Observations By:	KC, Highways Development Management
Application No.	2025/92160
Proposed Development:	Discharge of details reserved by Conditions 24 (Surface Water Strategy), 25 (Exceedance), 26 (Temp Surface Water), 27 (Interceptor), 29 (Sewer Easement), 30 (Foul Water), 31 (Archaeological Investigation), 34 (Road Condition Survey), 35 (CTMP), 40 (Retaining Walls), 41 (Travel Plan) on previous permission 2023/90668 for demolition of existing buildings; erection and operation of single building comprising Sui Generis land use limited to the purpose of storage, assembly, sale and distribution of custom-built computers, laptops and their components as well as any associated development (those being a replacement wind turbine, utility provision, drainage, access, hard and soft landscaping) within the red-line boundary alongside business operations pursuant to the effective administration of the Sui Generis use

Location:	Grange Moor Coachworks, Barnsley Road, Grange Moor, Huddersfield, WF4 4DR
OS Map Reference	SE 422205.463 415217.12
Applicant/Agent:	Acumen Designers & Architects Ltd
Class:	No Required
Site Area (sq. m):	72396.0

Consultation Response from KC, Highways Development Man

Construction Site Layout Plan

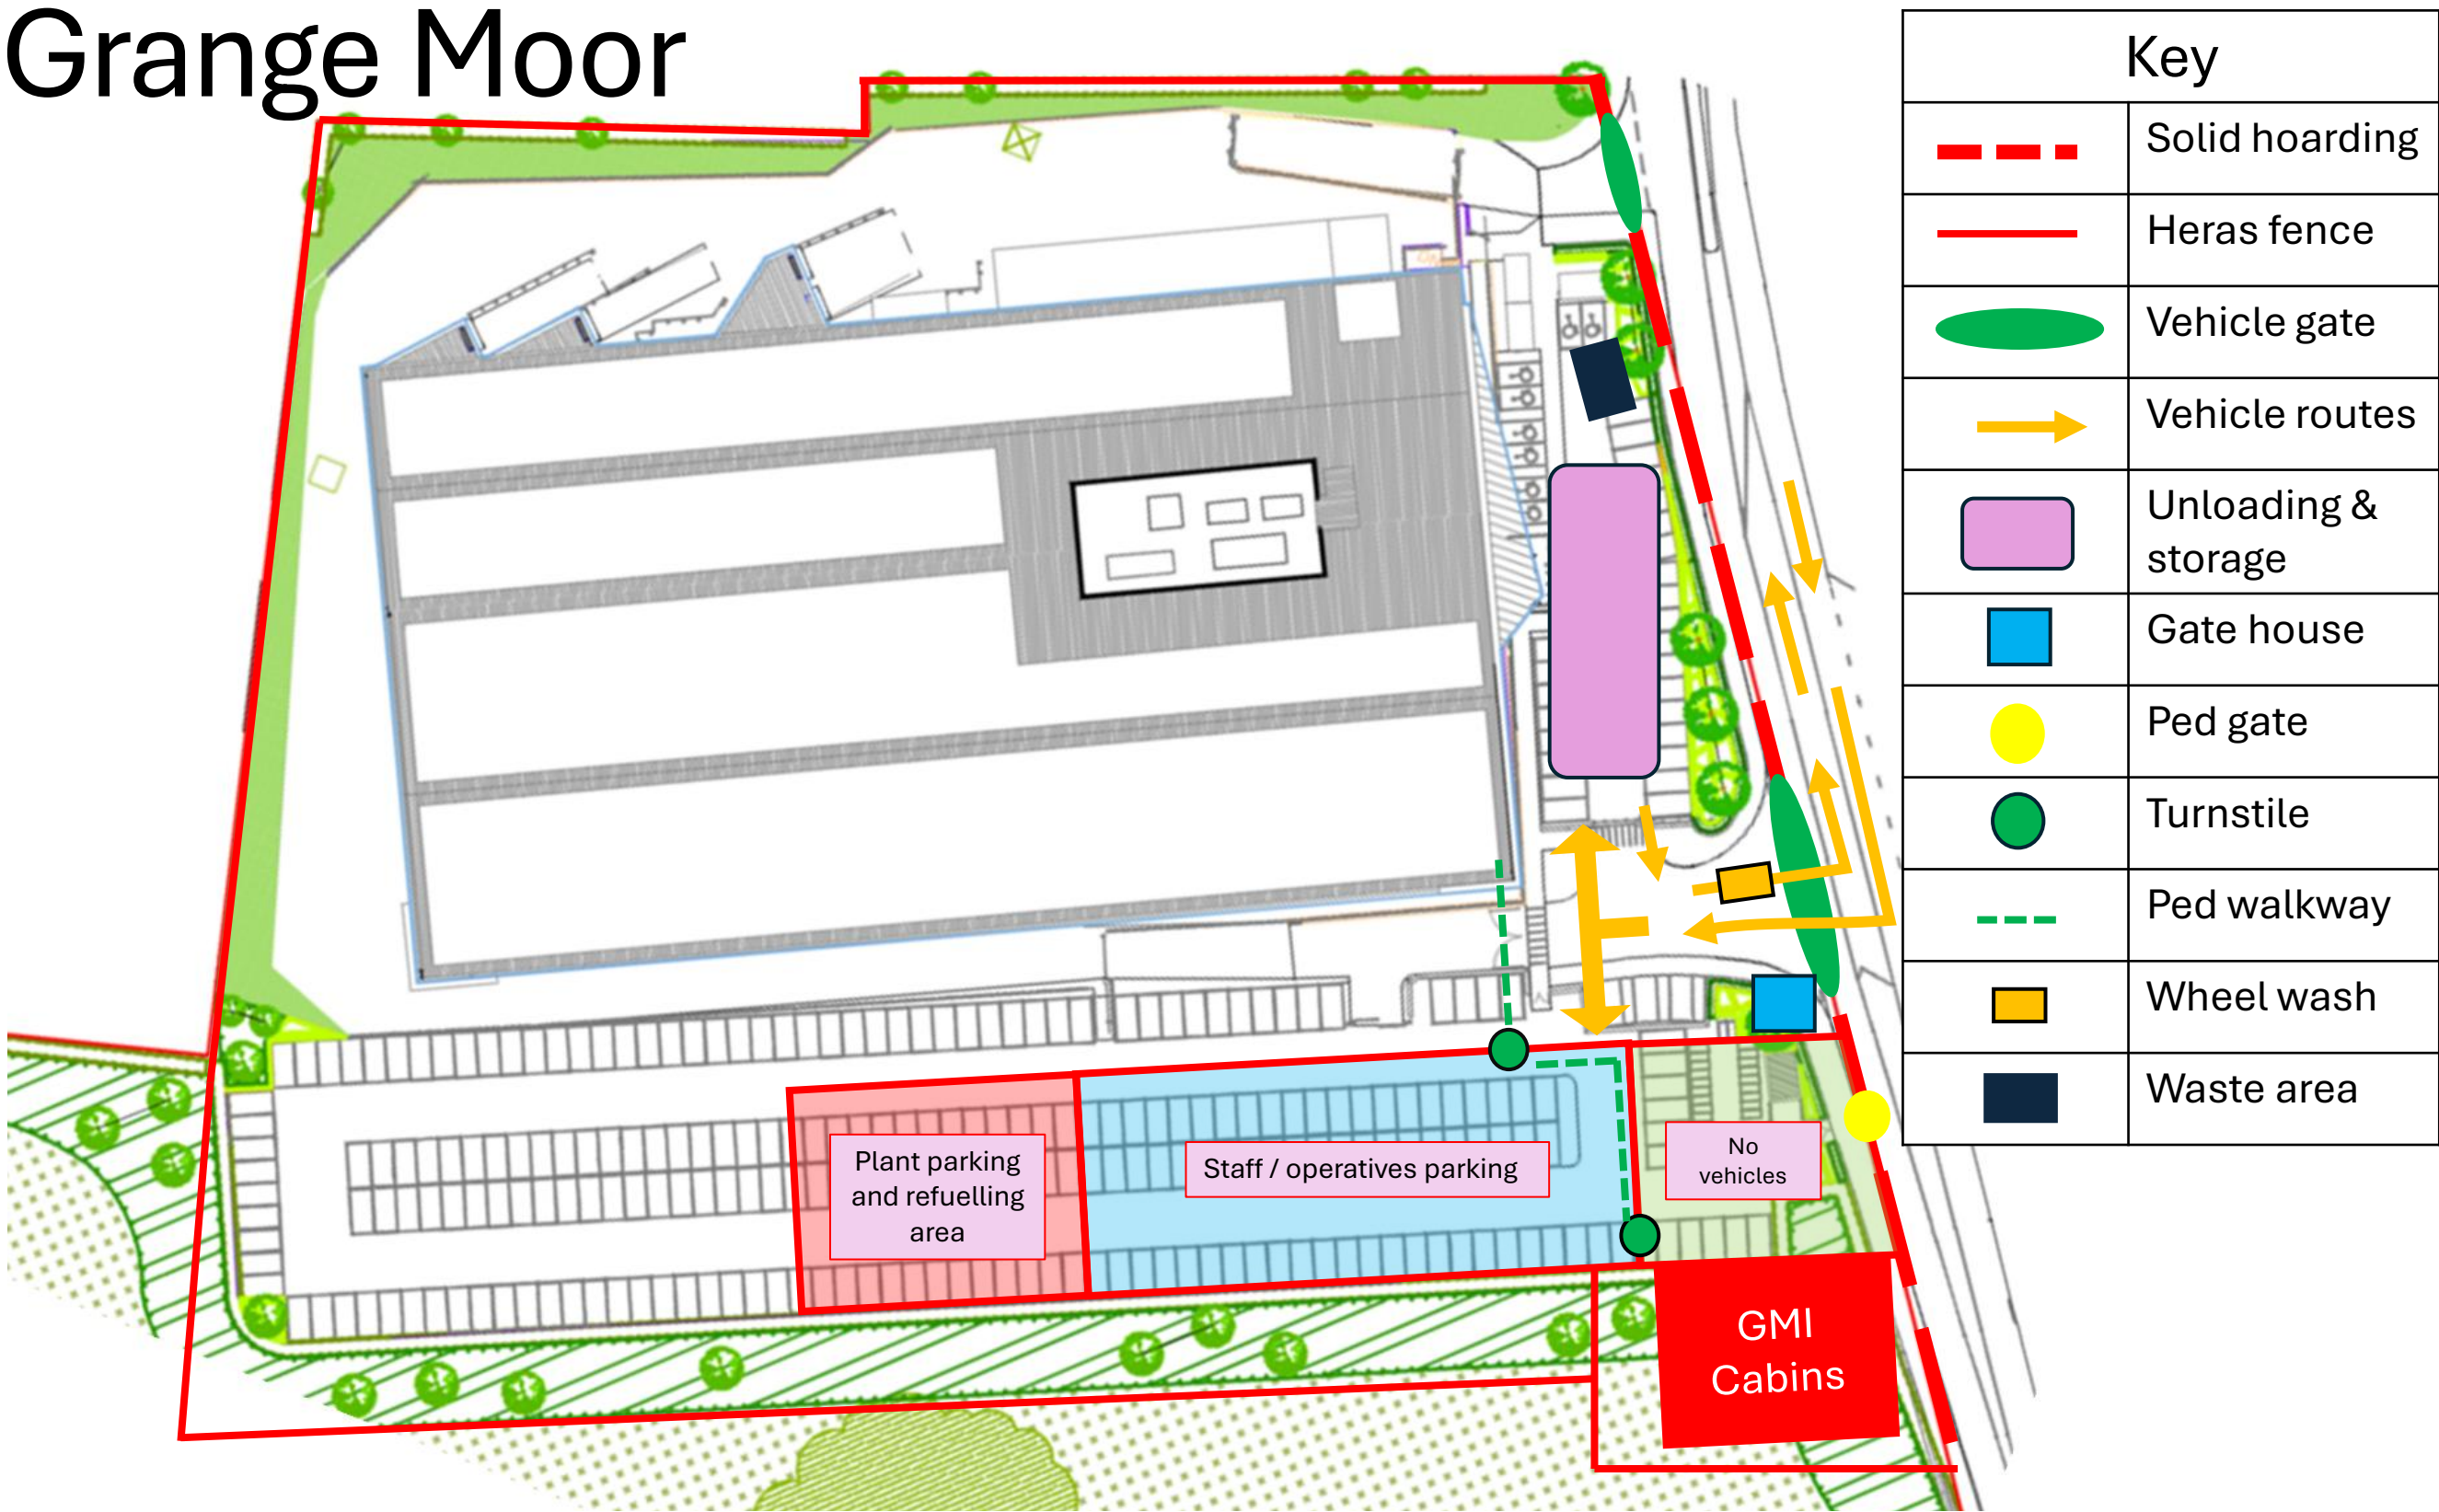
- Locations of HGV waiting areas and details of their management;
Parking areas for HGVs are shown in the drawing in Appendix B. No off-site waiting areas are indicated.

- Parking for construction workers;
Suitable contractor parking is indicated on the drawing in Appendix B.
- Loading and unloading of plant and materials;
Suitable loading and unloading areas are indicated on the drawing in Appendix B.

- Storage of plant and materials;
This is included within section 6 and suitable storage for plant and materials is indicated on the drawing in Appendix B.

- Signing and traffic management arrangements during construction works;
This is covered in section 2 paragraphs 2.14 and 2.15
- Measures to be taken to minimise the deposit of mud, grit and dirt on public highways by vehicles travelling to and from the site, including the provision of adequate wheel washing facilities and street sweeping;
This is covered in section 5.2 and a suitable wheel washing facility is indicated on the drawing in Appendix B.

This information is deemed acceptable and is suitable for the discharge of condition 35 of previous permission 2023/90668.
